**chrKIRKLEES METROPOLITAN COUNCIL
INVESTMENT & REGENERATION SERVICE**

**DELEGATED DECISION FOR APPLICATION FOR CERTIFICATE OF
LAWFUL DEVELOPMENT**

Reference no.: 2024/CL/92462/W

Site: 2, The Green, Marsden, Huddersfield, HD7 6DE

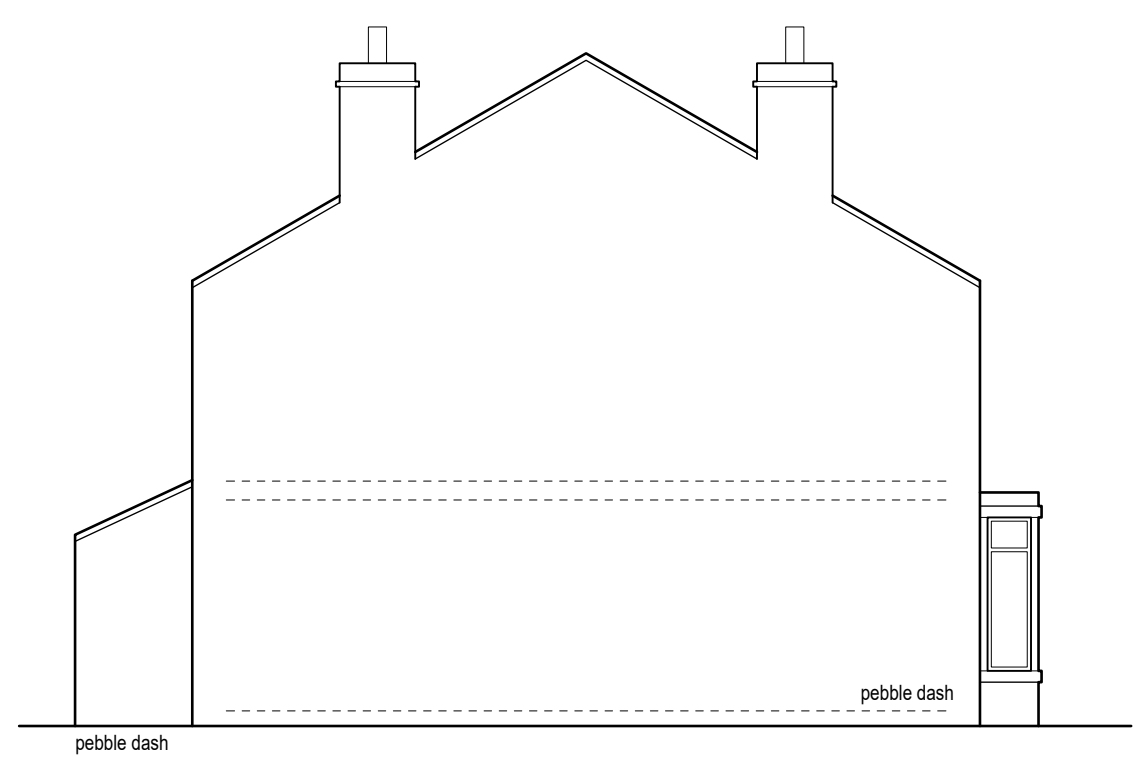
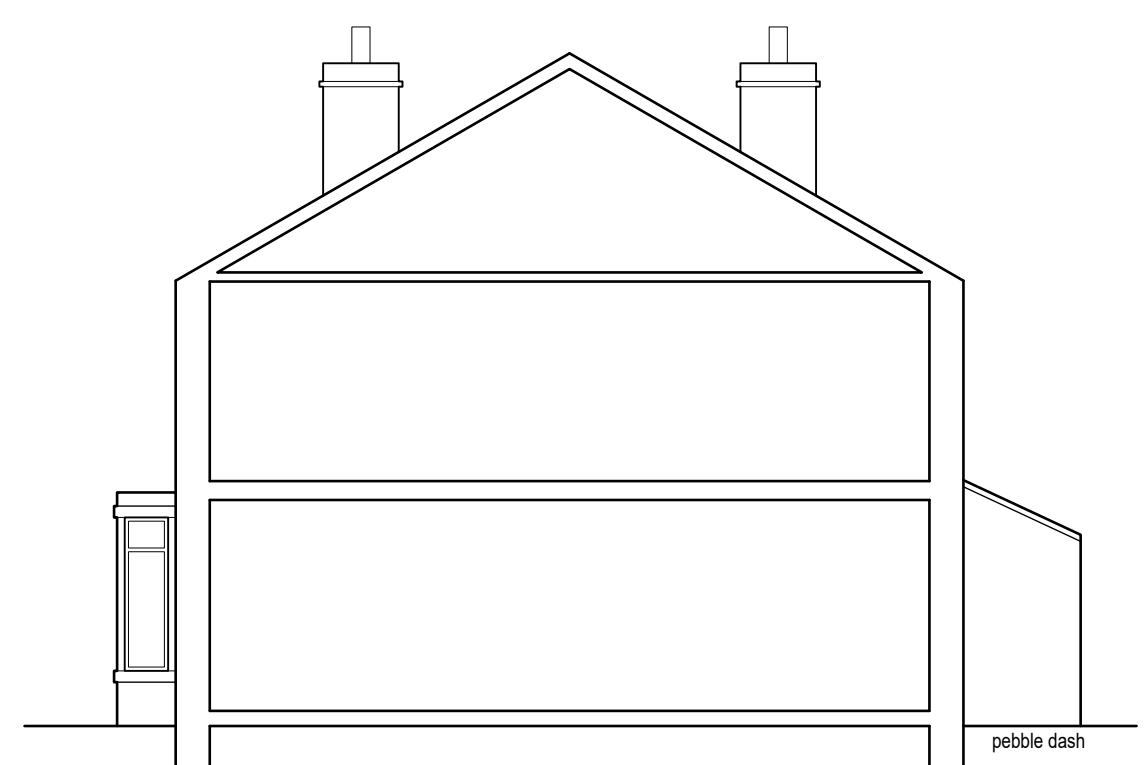
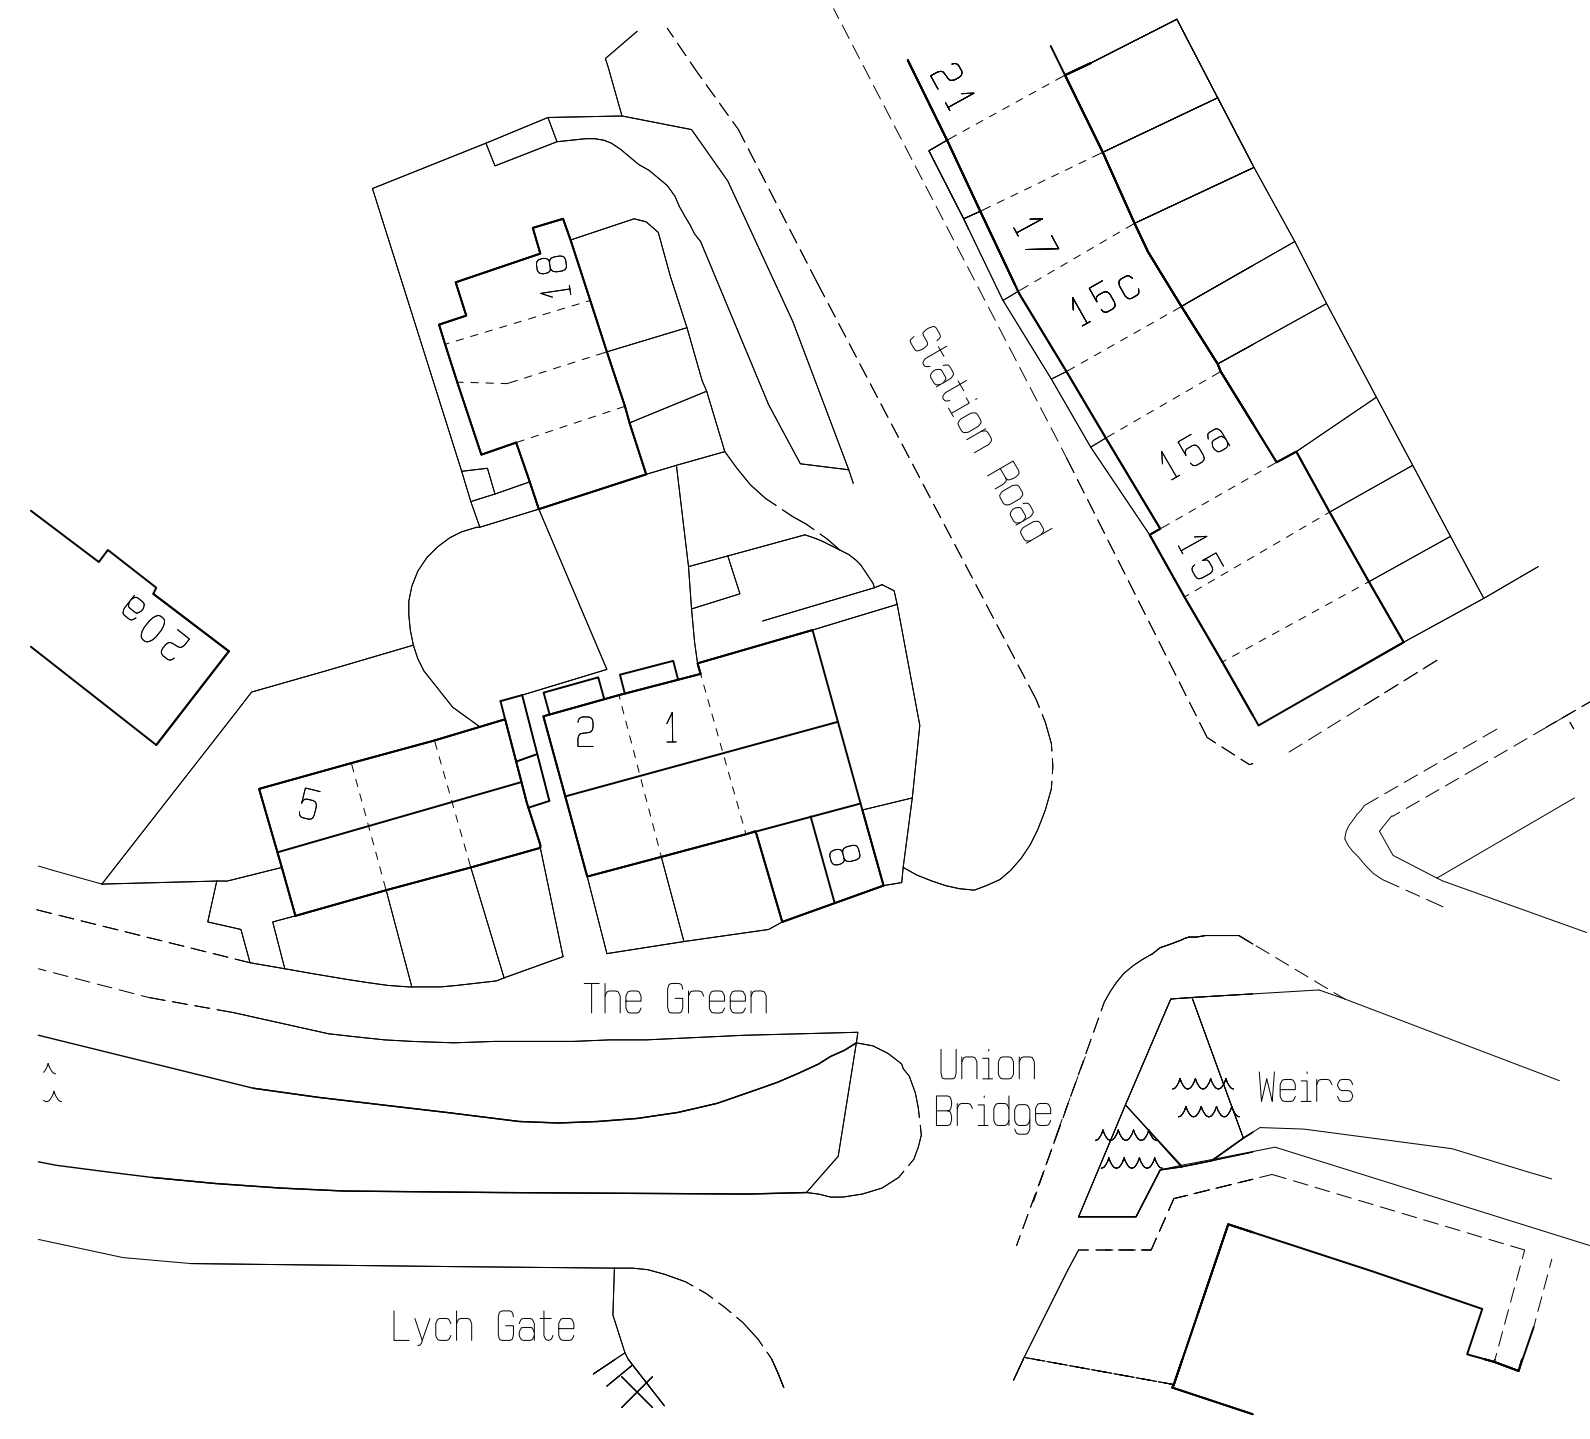
The extension, measured from the provided drawing at 1:100 scale, would project from the rear elevation of the property by 1.55 metres and would be a total width of 3.75 metres, with an eaves height of 2.25 metres, rising to an overall height of 3.05 metres for the pitched roof.

Comment: *The enlarged part of the dwellinghouse would be single storey in scale, would not extend beyond the rear wall of the original dwellinghouse by more than 3 metres and would not exceed 4 metres in height.*

Comment: *the enlarged part of the dwellinghouse would be within 2 metres of the boundary of the curtilage of the dwellinghouse, although the height of the eaves of the enlarged part would not exceed 3 metres.*
